Document No: LE03-01-SY23-127-
CBB-CoE-Fire-Tank-
Configuration.docx

**RE: State Significant Development Application (SSDA-69627466) - 3 Edison Lane,
Belmore - Fire Tank Configuration**

UPPER LEVEL VIEW - PROPOSED FIRE TANKS

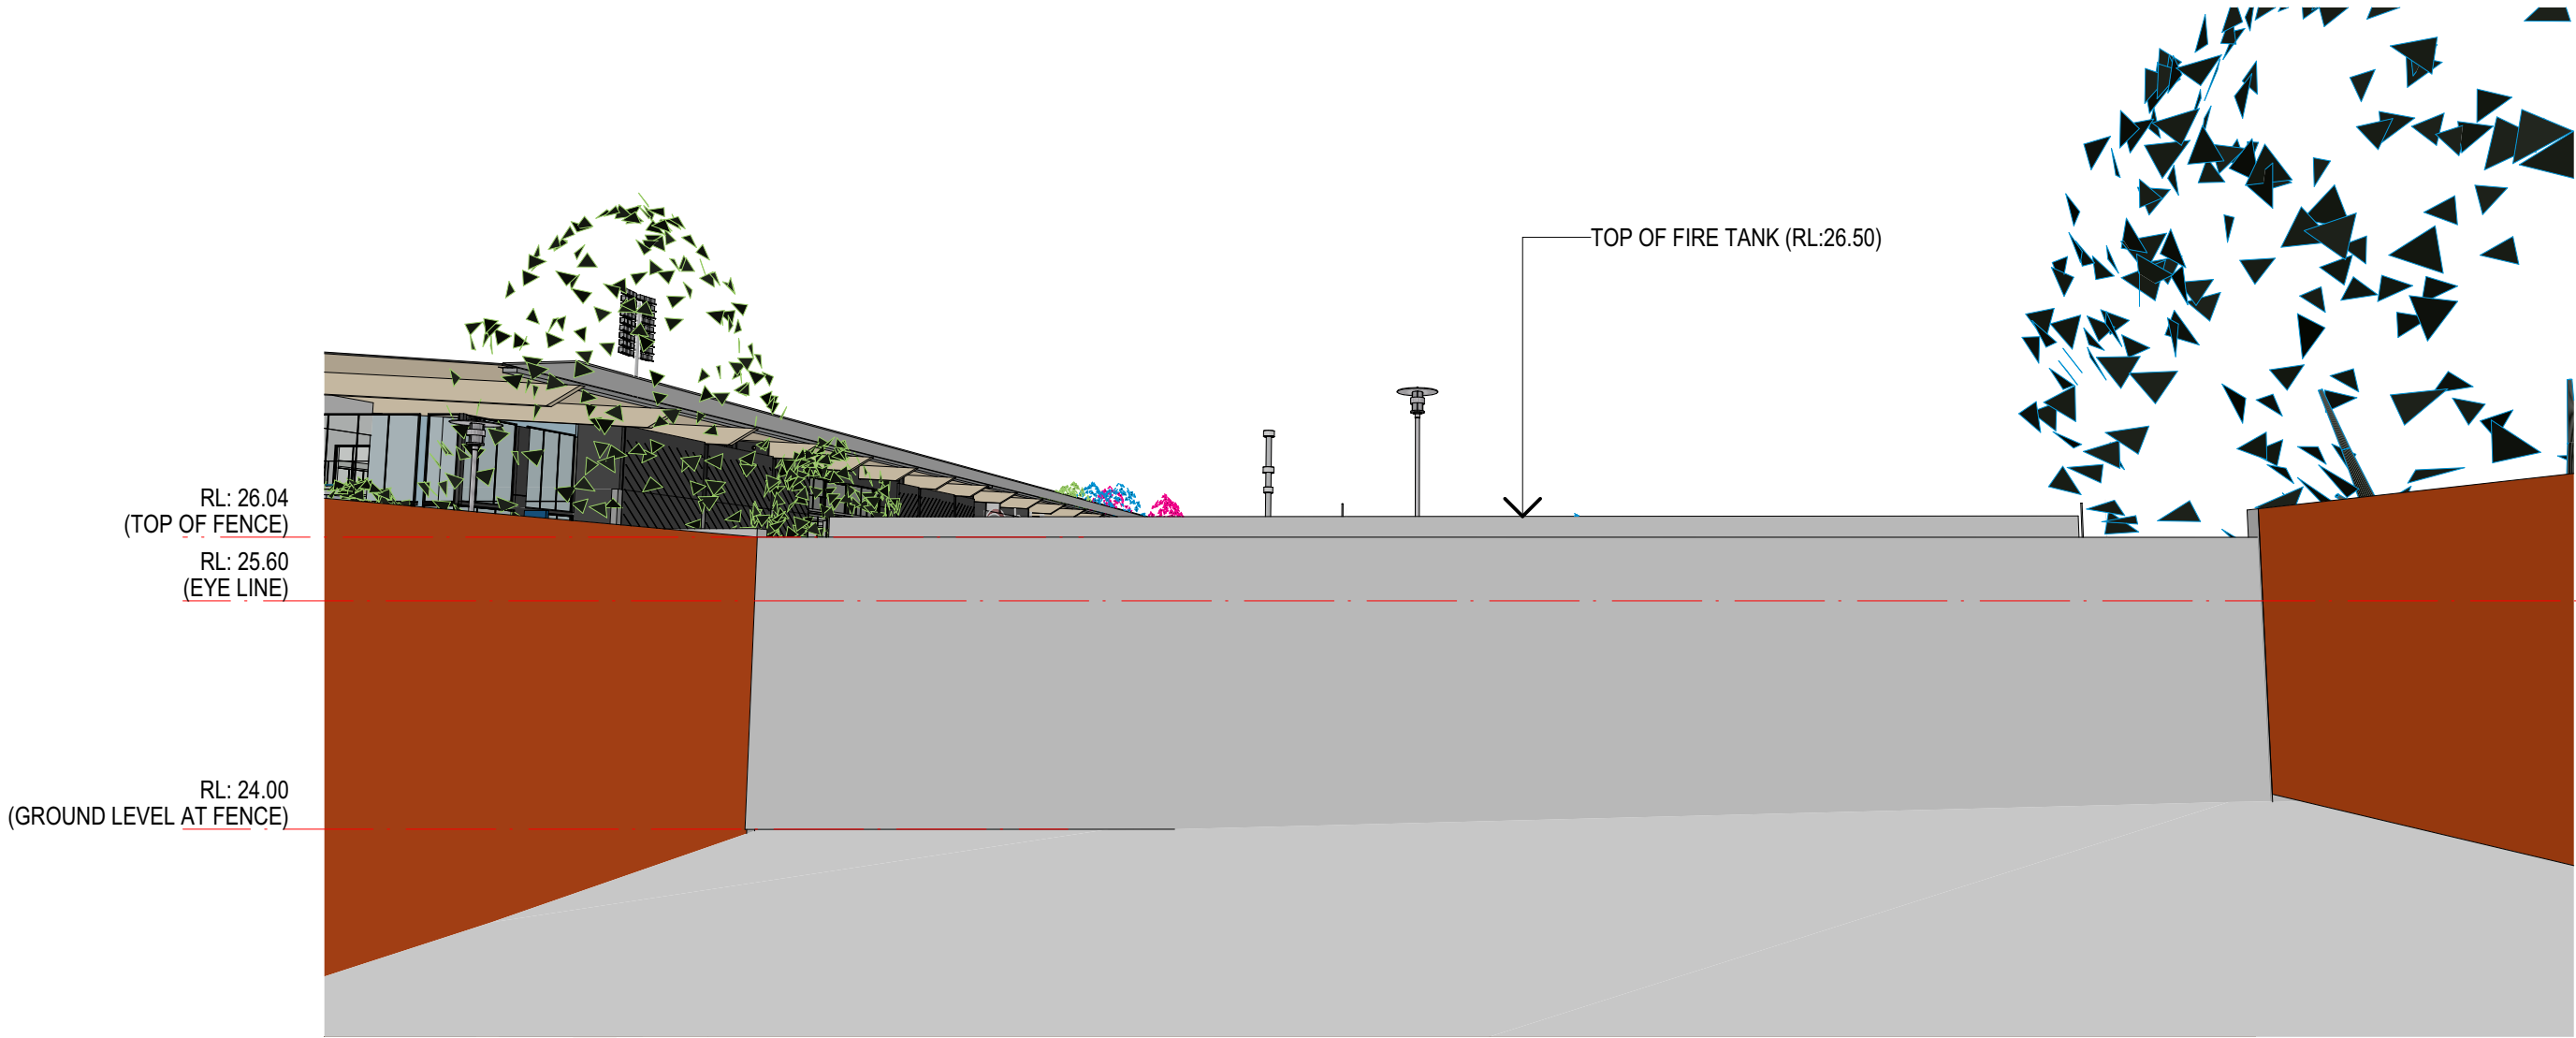
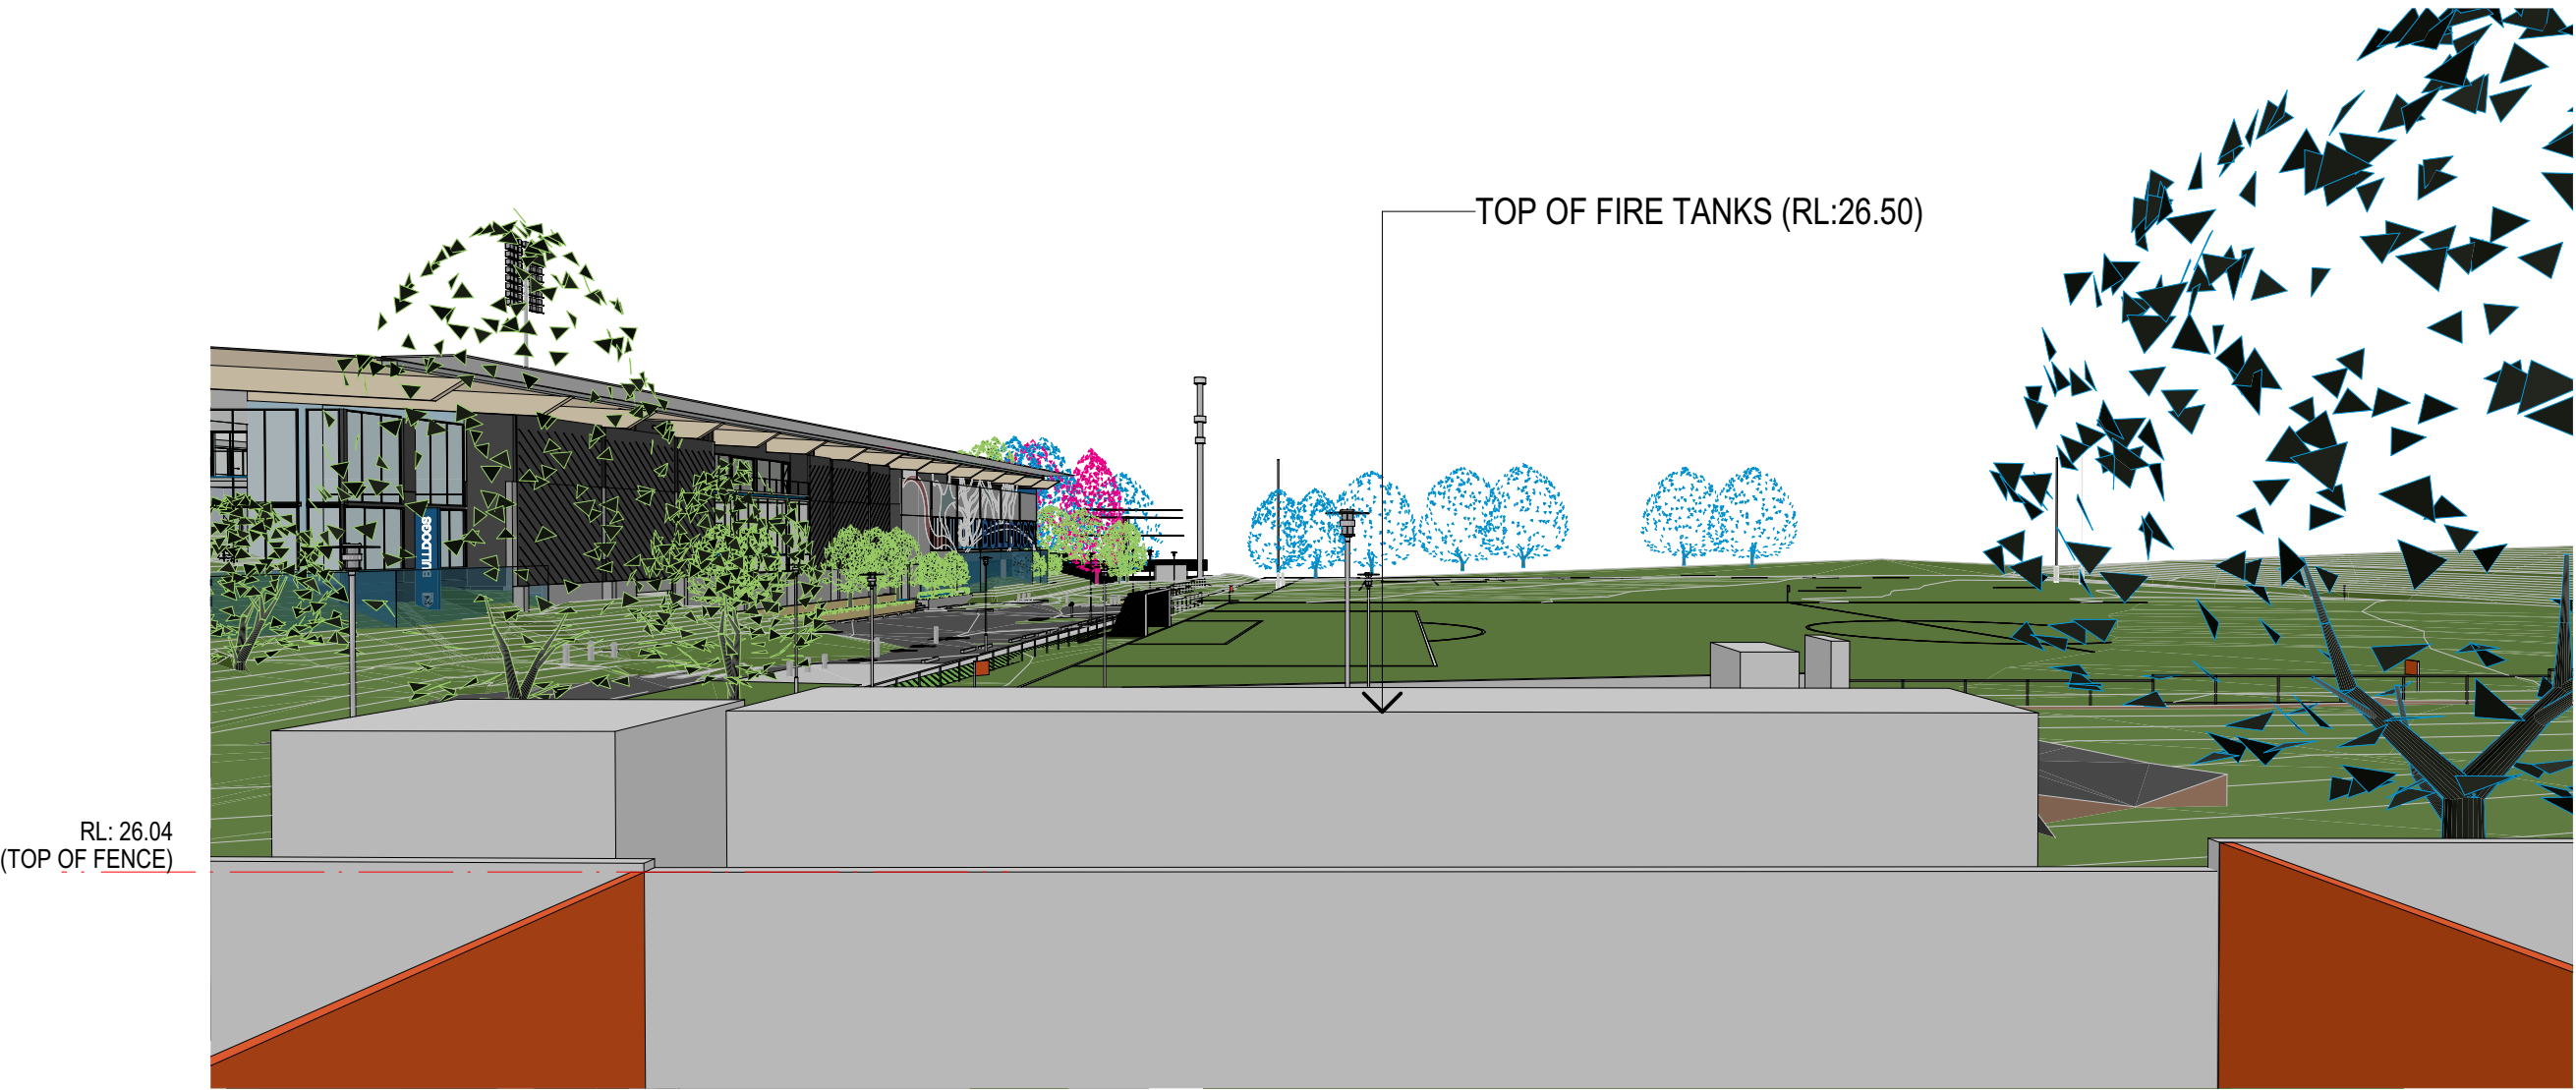
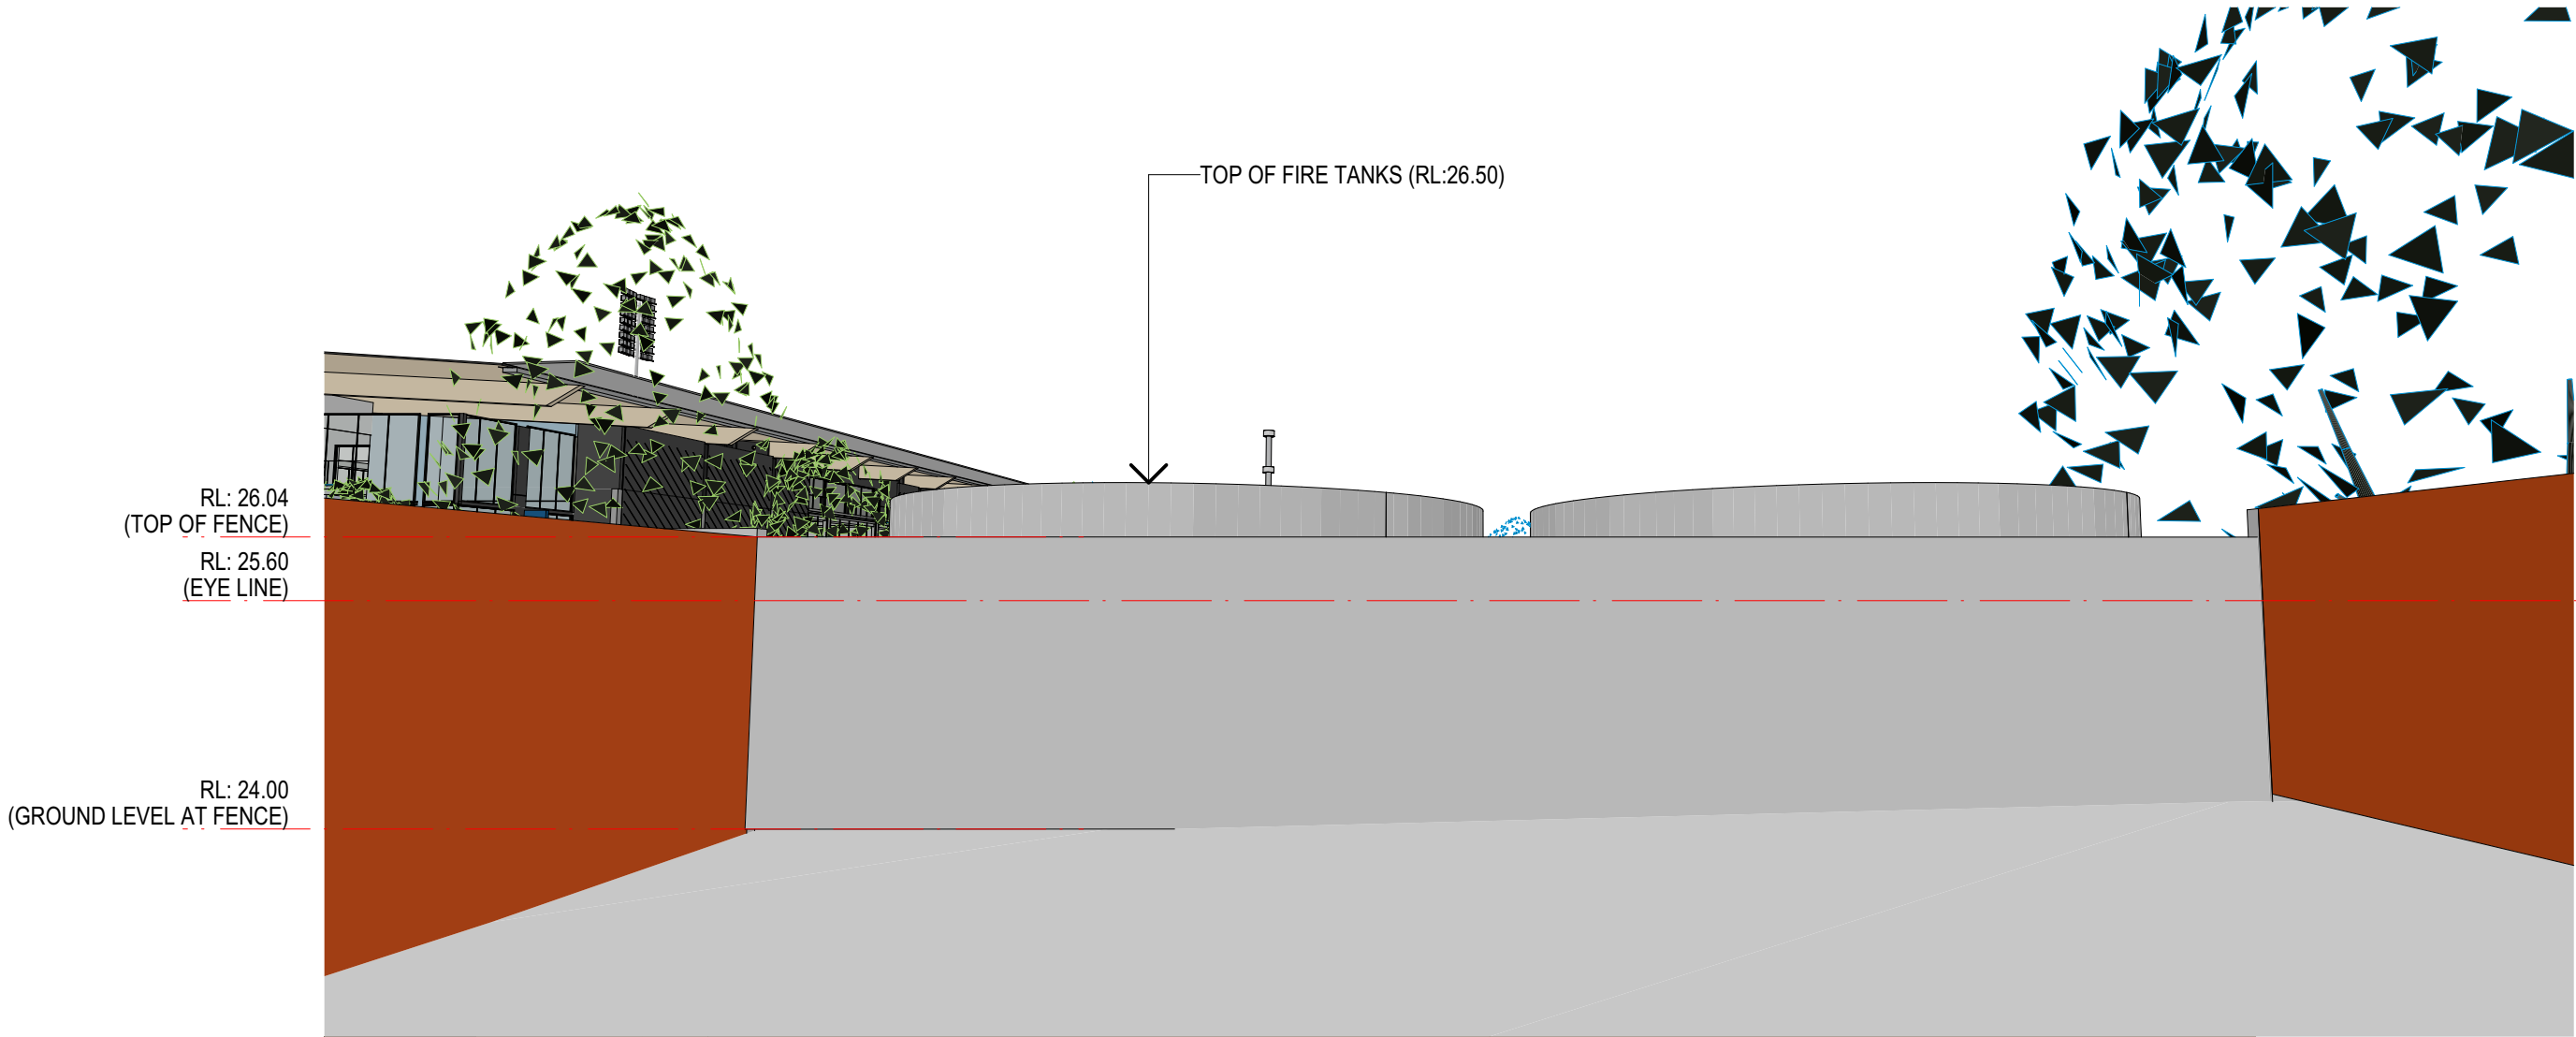
This letter is prepared by Sky Engineering & Project Management Pty Ltd in response to the justification to the alternative configuration of the fire tank which differs from the original SSDA application. The original SSDA submission illustrates the proposed fire tank as being a circular tank, see figure below.

After the SSDA submission the tank had been reconfigured to rectangular tanks, during detail design.

The change in tank shape configuration is based on the following:

To conclude, based on existing utilities constraints and additional Council's drainage easement, the design of the fire tank has been evaluated appropriately to suit services authority and Council's requirements. Overall, the design intention is the same as the original submitted SSDA application.
